Our reference: ECM: 9229901
Contact: Gavin Cherry
Telephone: 02 4732 8125

26 August 2020

**Response to Notification of State Significant Development Proposal – ESR
Horsley Logistics Park (SSD10436)**

LOT 201 FINISHED LEVELS PLAN - SHEET 1
SCALE 1:500

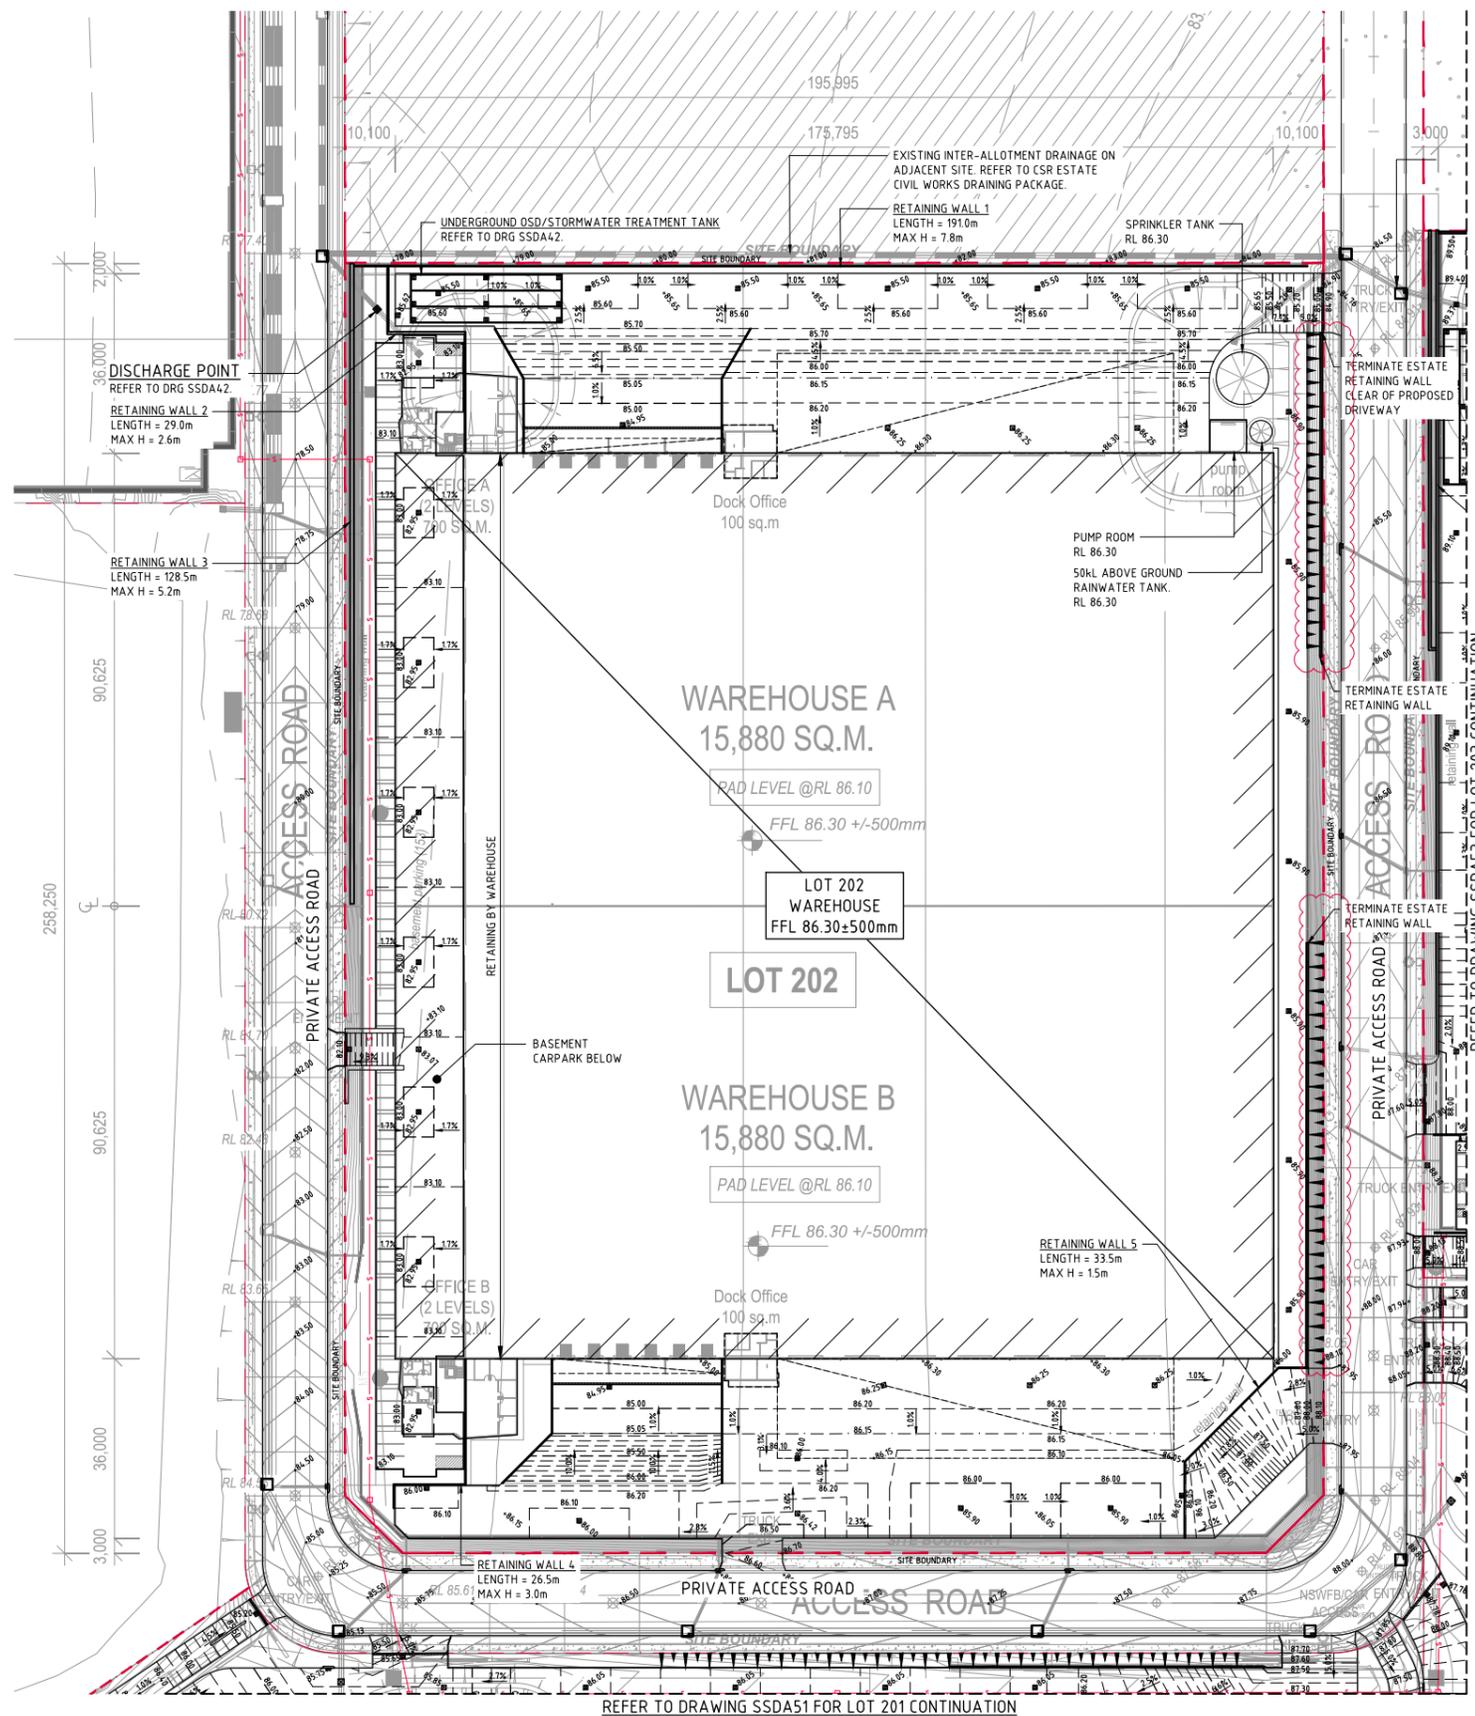
The proposed finished ground level of the car park on Proposed Lot 201 is RL86.00 which is 5m higher than the adjacent spot level to the north western corner of Lot 201 being RL81.00 (as indicated on the landscape drawings). It is noted at that at the south western corner, the natural ground level adjacent is the same as the car park finished level. While cross sectional drawings are provided to the north and south of lot 201, they are not in the locations of the greatest cut and fill. Further a critical interface consideration is to the western property boundary, as a 5m high retaining wall at the north western corner (as indicted by the plan levels) is not a suitable or sympathetic interface outcome.

If the finished ground levels (up to 5m above neighbouring natural ground levels) are required to achieve suitable stormwater drainage, then stepped and tiered retaining walls should be provided to the interface boundaries so that the landscape design can negate the visual impact of the proposed level difference and retaining walls (as viewed from the adjacent allotment). This would require a widening of the boundary landscape setbacks in these locations to Matrix A at a minimum (not Matrix B) and a resulting reduction / change in the car parking arrangement. Alternatively, it should be demonstrated how a 5.0m level difference can be otherwise treated to ameliorate its impact as viewed from the adjacent land holding.

It is requested that additional cross-sectional drawings in the locations of maximum level difference be requested that better address boundary edge conditions, with landscaping incorporated into tiered retaining walls to ensure that vertical walls of more than 2m on property boundaries, or as visible from neighbouring properties, are avoided.
